West Nowra Landfill Expansion (SSD-7187)
Response to Submissions

Attachment 1- Department of Planning, Industry and Environment Comments

Figure 22 Predicted 99th Percentile Nose-Response Odour Concentrations (Includes Leachate Irrigation)

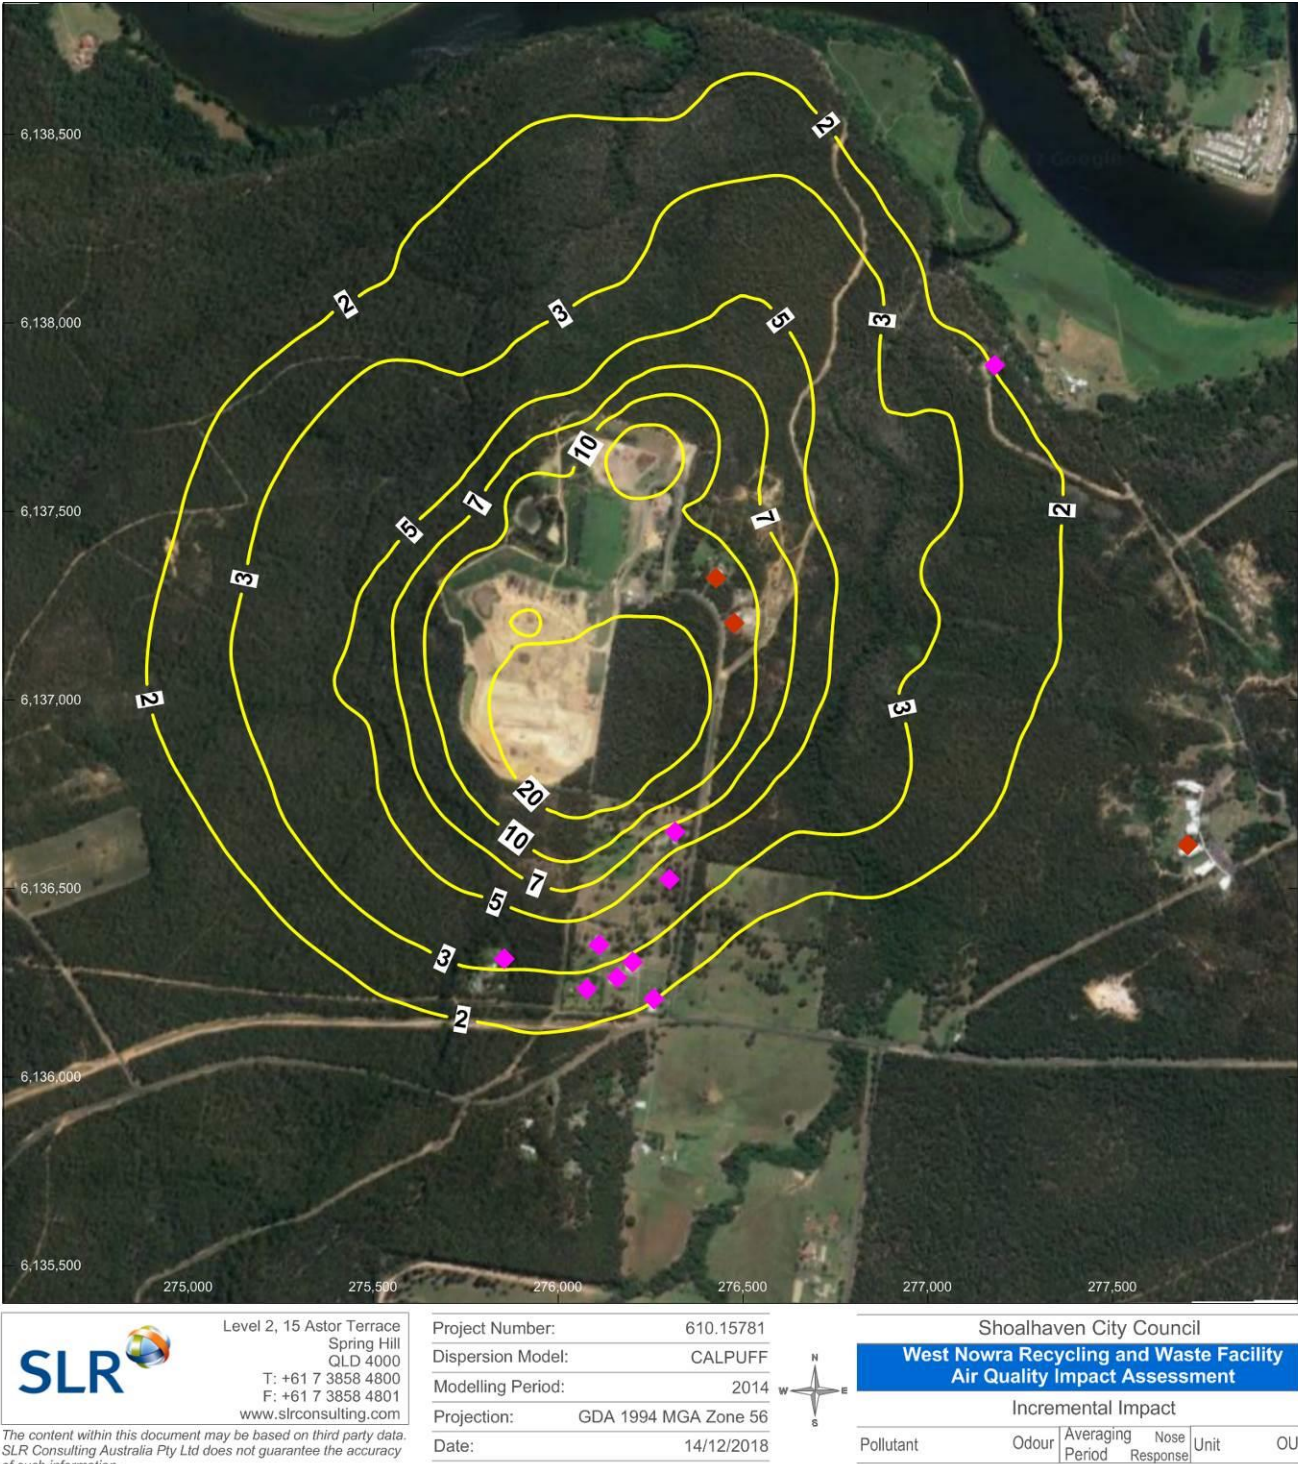
5. It is noted there are predicted odour exceedances at one residential and two commercial premises, however mitigation measures are proposed. Please update odour modelling to include implementation of the mitigation measures.
